Drafted 18 May 2012

**Planning Application, Ribble Valley District
3/12/0411 127 Padiham Road, Sabden**

I have no objection in principle to this application on highway safety grounds.

Proposed Site Plan

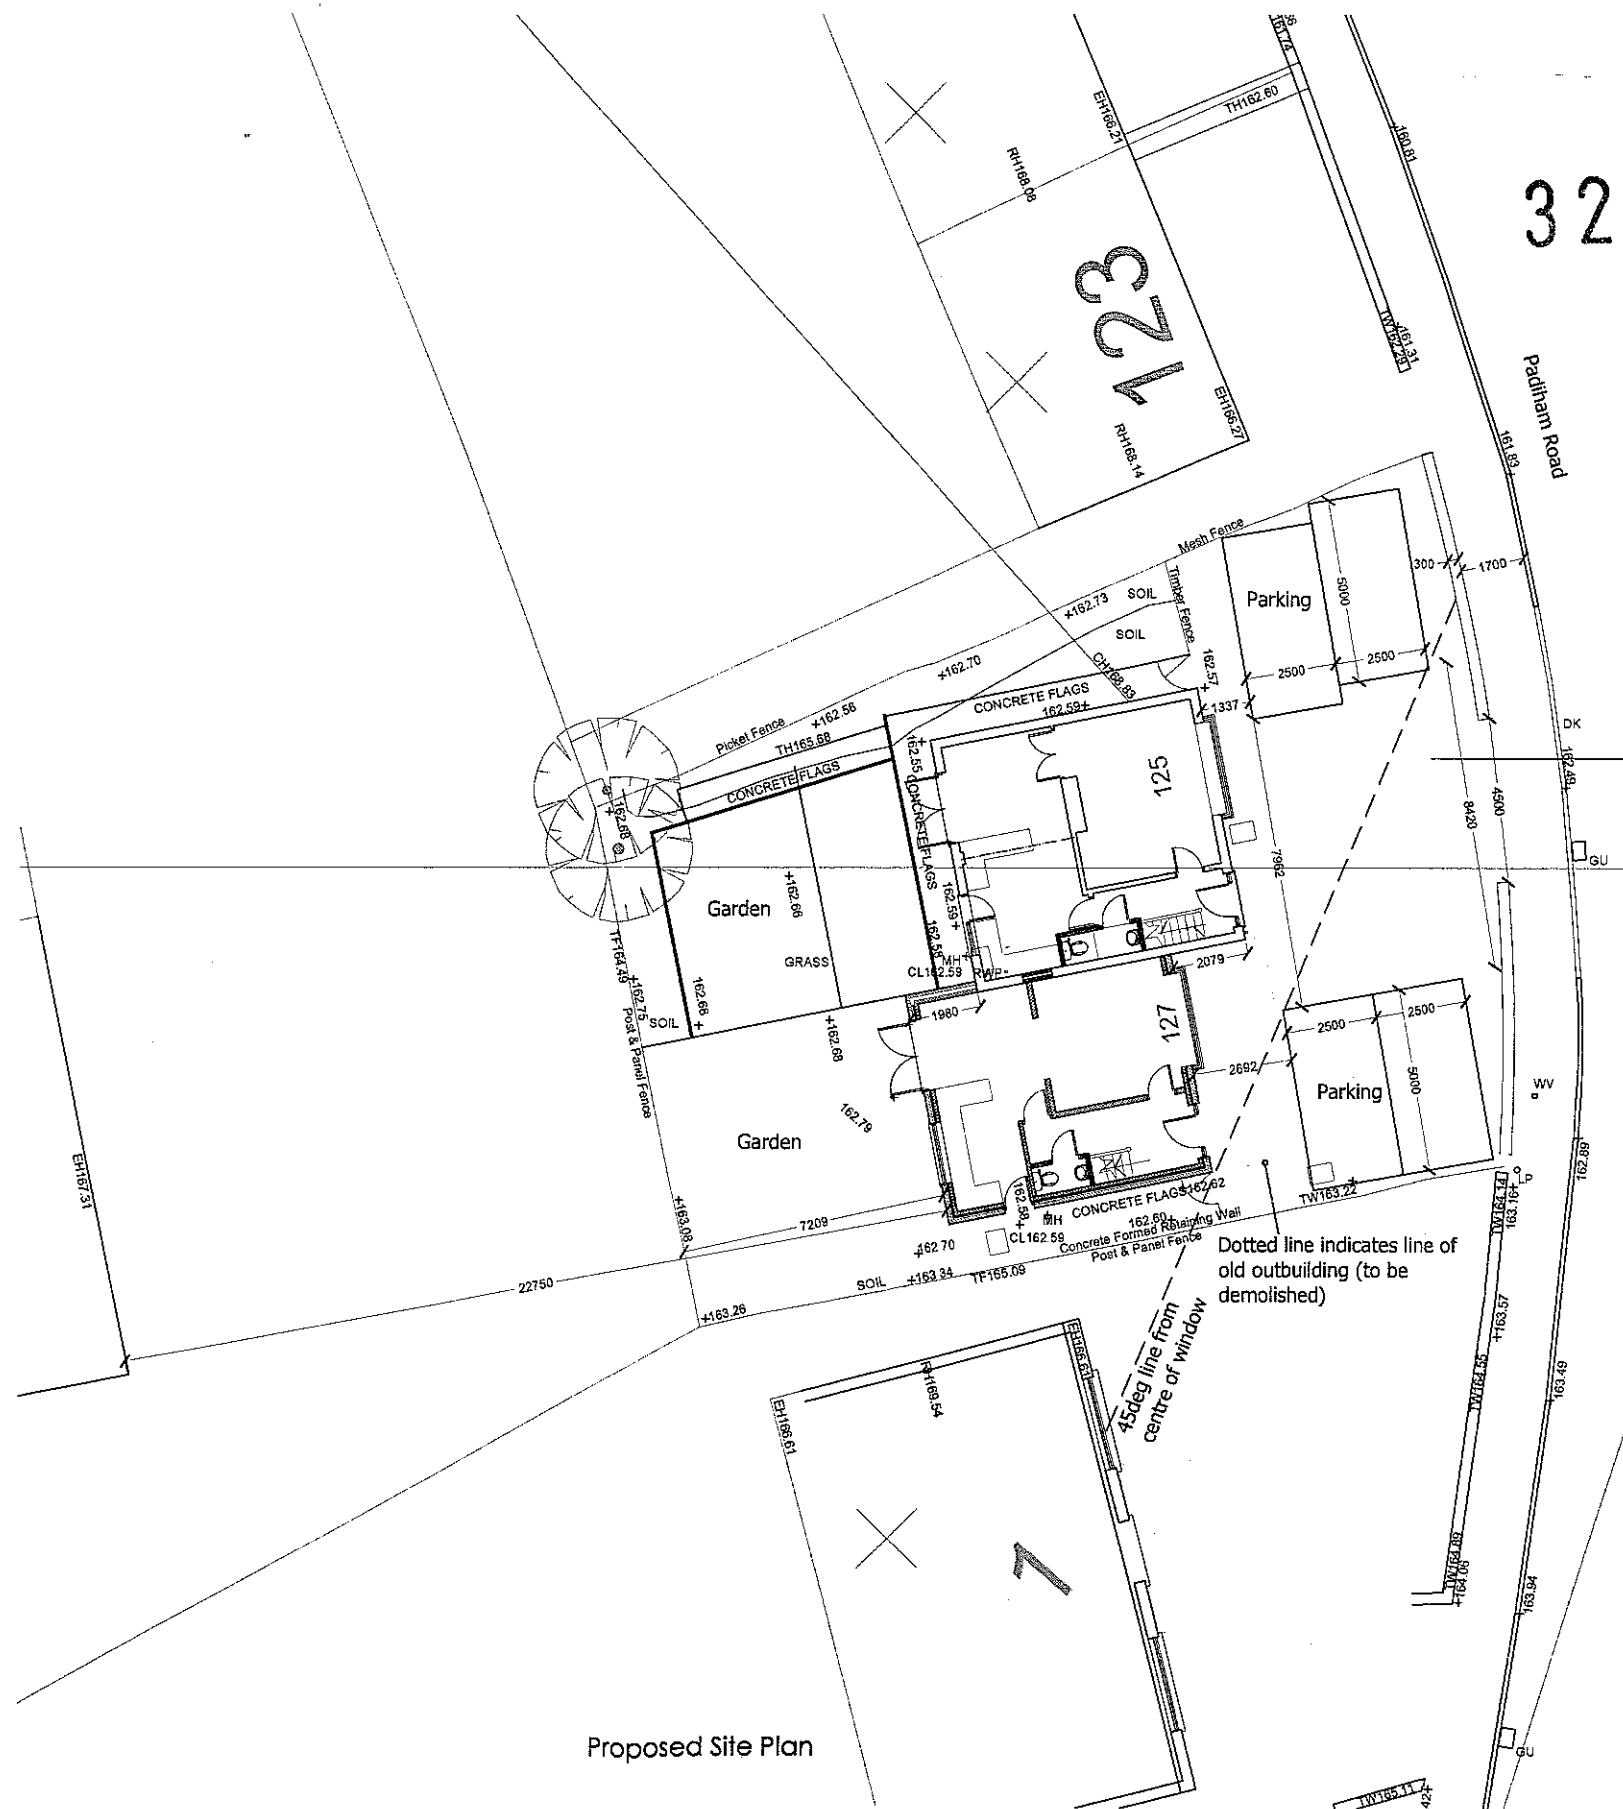
The proposed alterations to the operation of this site and the resulting changes to the layout secures the opportunity for 2 car parking spaces to each property and for these vehicles to access the site in such a way that there are no reversing manoeuvres to/from Padiham Road.
